**University of Newcastle, Honeysuckle City Campus Stage 1A (SSD 9510)  
Notice of Exhibition**

Thank you for your correspondence dated 2 August 2019 requesting Transport for NSW (TfNSW) comment on the above State Significant Development (SSD) Application, currently on exhibition.

CD19/06339

Figure 3-1 Vehicle Movements associated with Construction Works

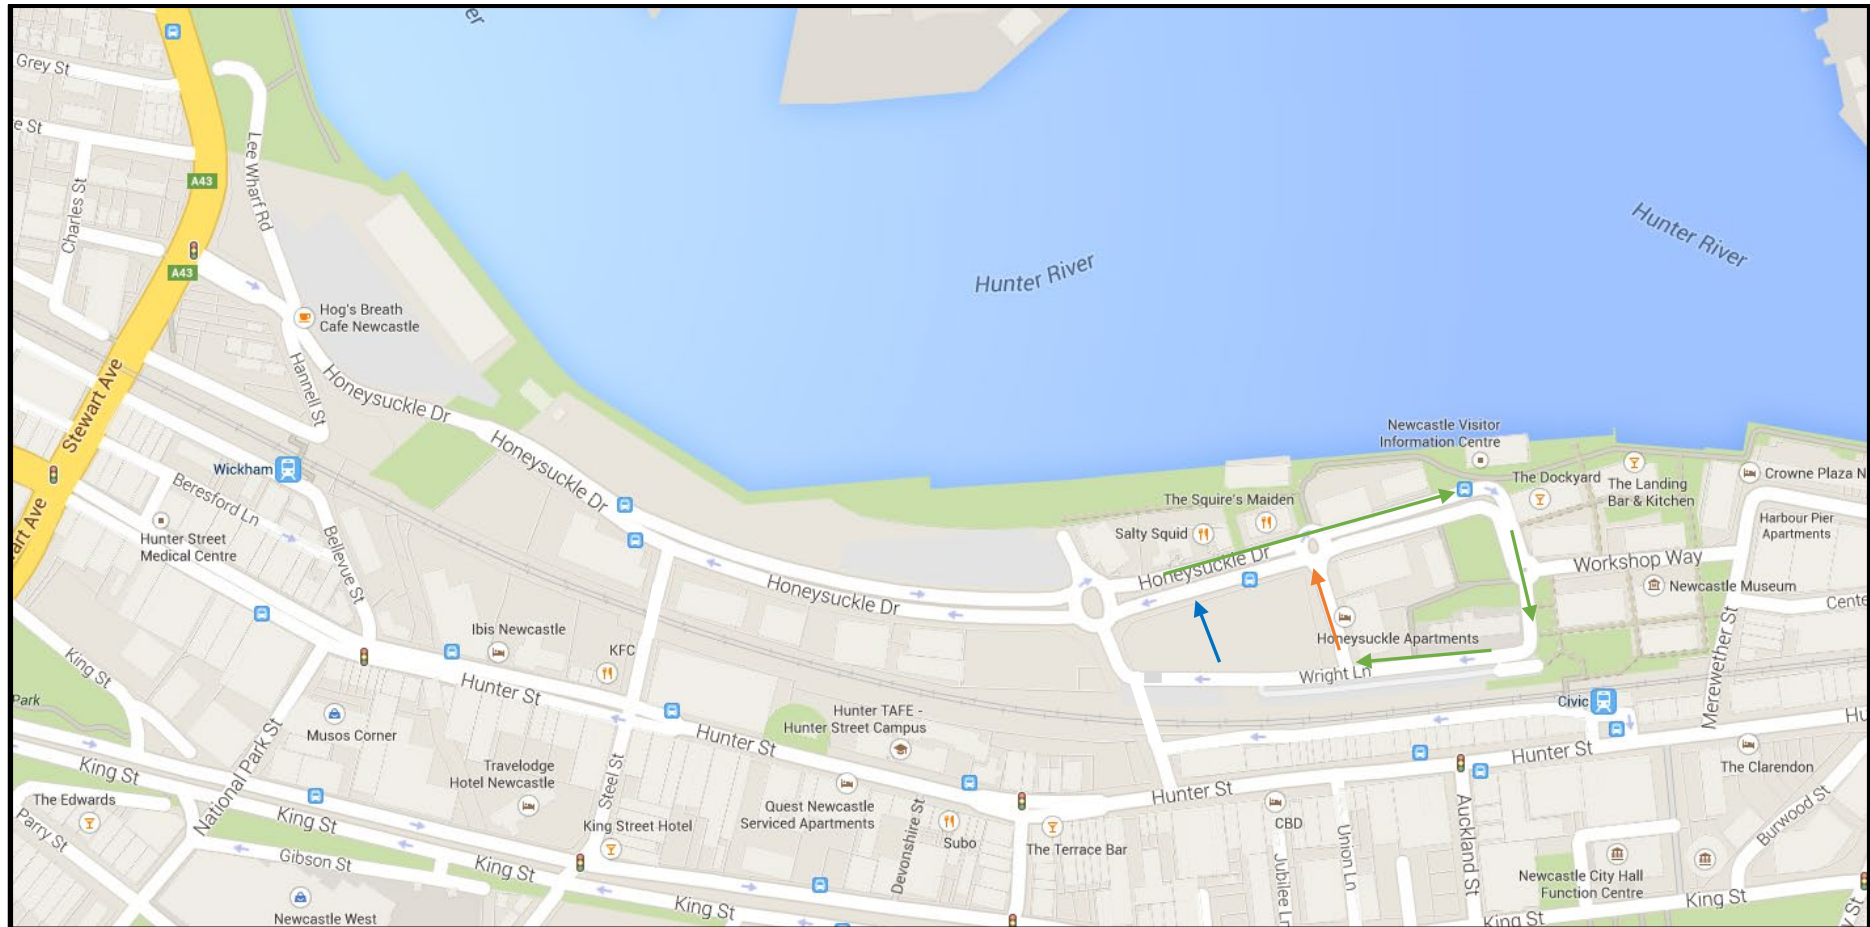
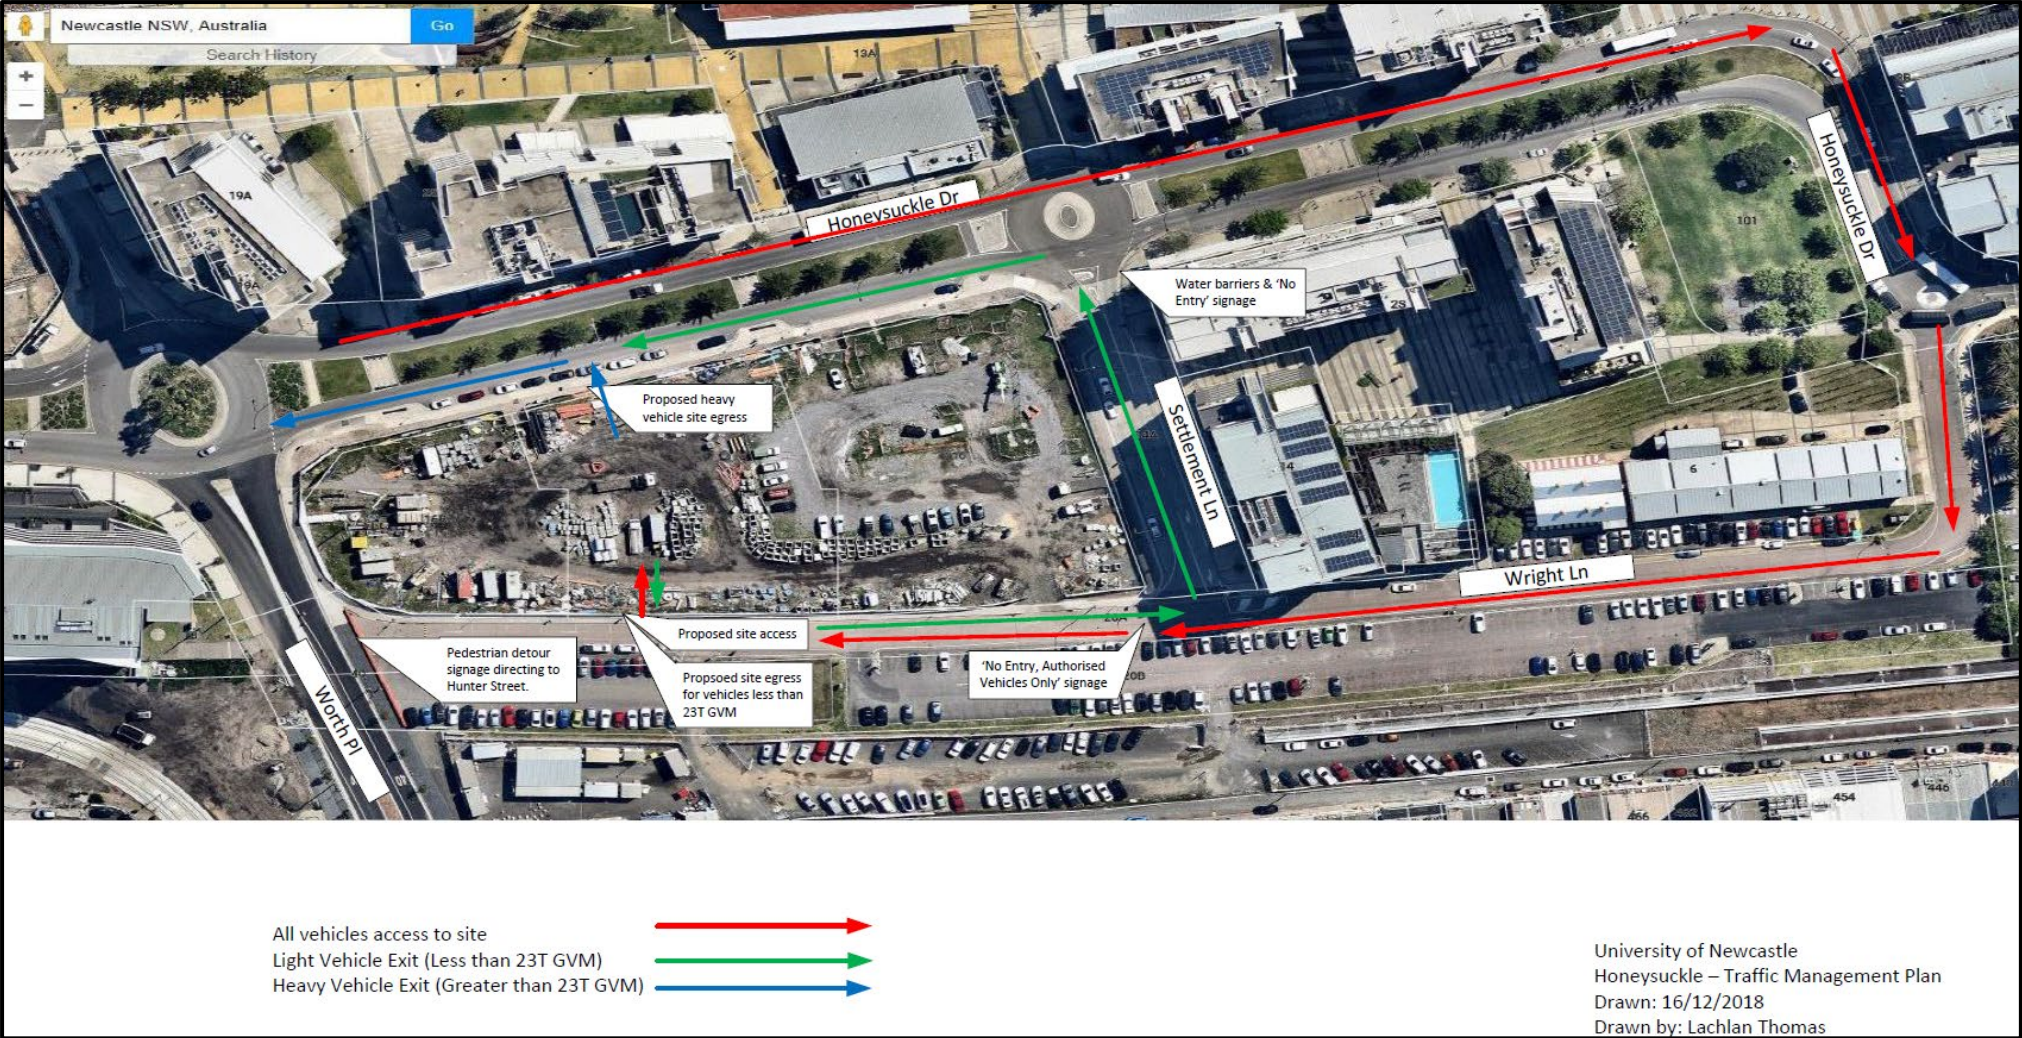
The proposal is in close proximity to the Newcastle Light Rail and frequent bus routes along King Street. Due to this proximity, the construction phase of the development could have potential impacts on both the Light Rail (construction and operation) and bus route operations.

Further design iterations of the development should include a Construction Traffic and Pedestrian Management Plan (CTPMP) to ensure construction stage impacts on the surrounding road network are mitigated. The CTPMP should demonstrate construction will not impinge on the operations of the bus or active transport network, ensuring pedestrian and bicycle rider movements along footways and cycleways are maintained at all times during construction activities.
